**Our ref:** WA/2014/116967/02-L01  
**Your ref:** 14/00009/DISC

**Date:** 28 July 2014

**Partial discharge of condition 13 - surface water drainage assessments for Tubbs Lane footbridge and Bicester Town Station of TWA/10/APP/01 Oxford to Bicester rail link**

Appendix 2 – (AP2) Tubbs Lane Drainage Design

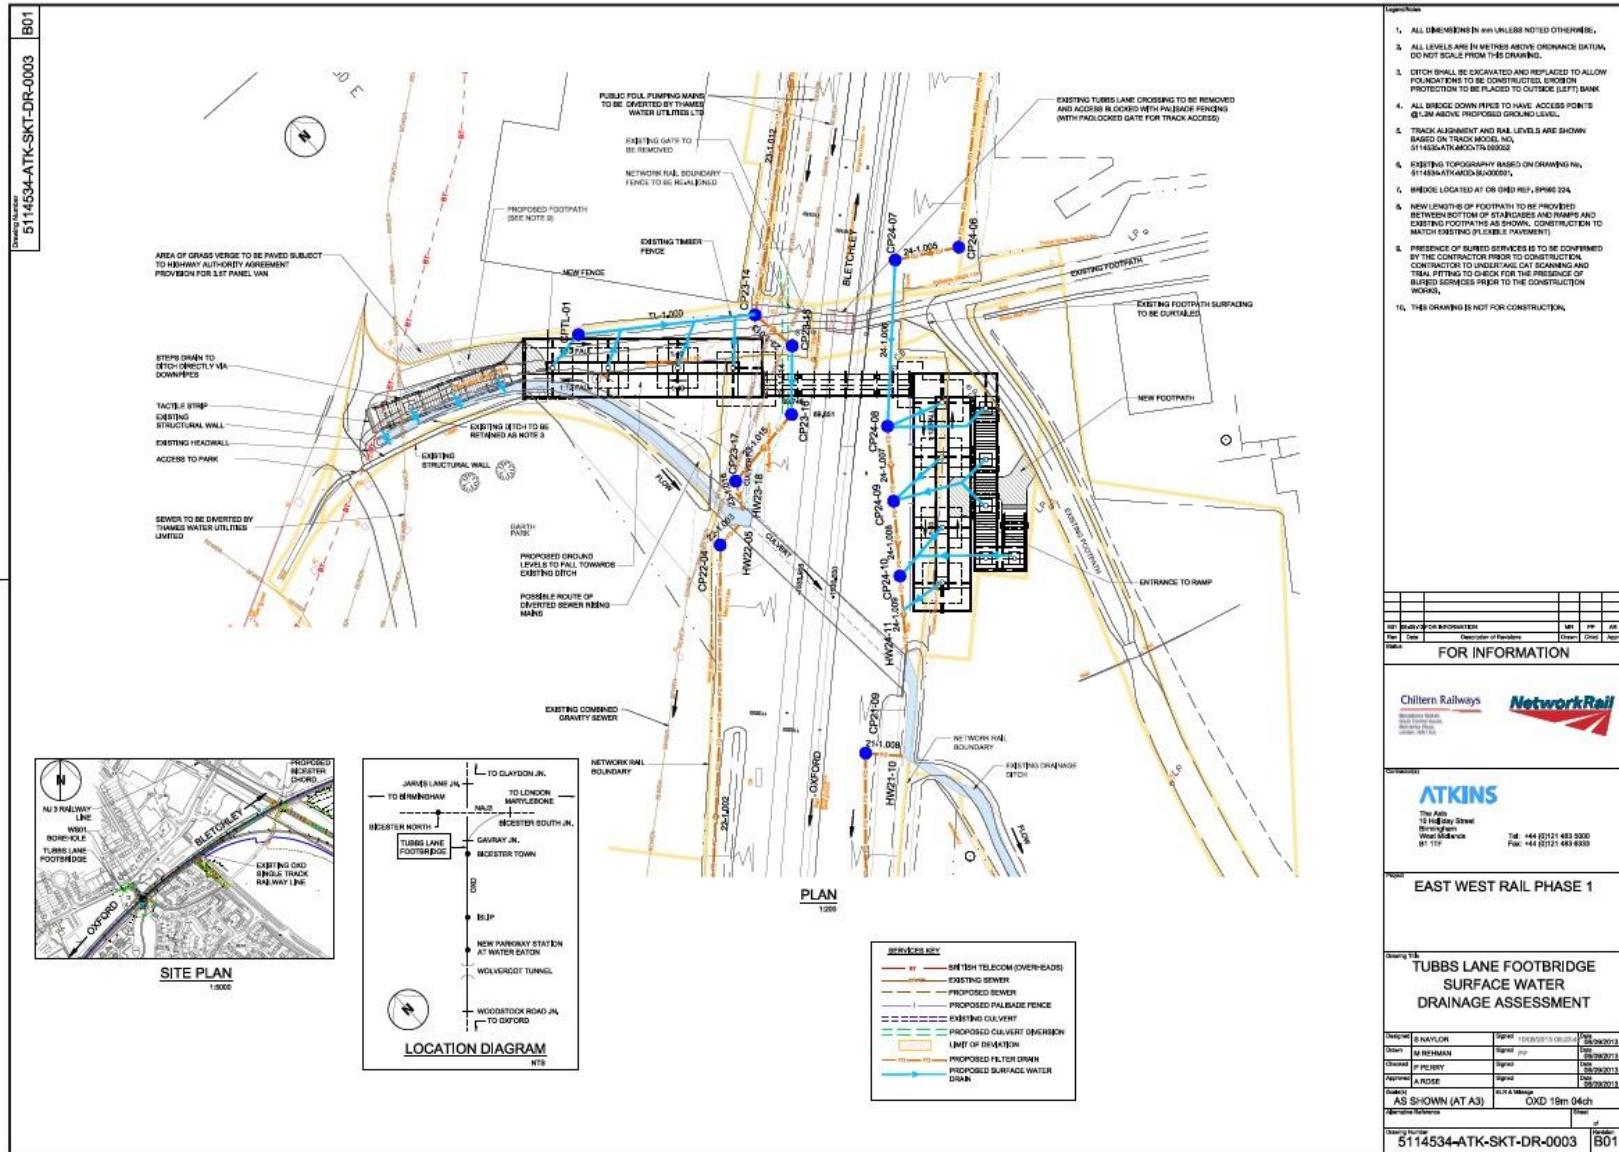
Given the tiny amount of runoff from the proposed Tubbs Lane bridge, we have no objection to this being mitigated through the upgraded drainage at Bicester Town Station.

We therefore have no objection to the discharge of Condition 13 in relation to Tubbs Lane footbridge.
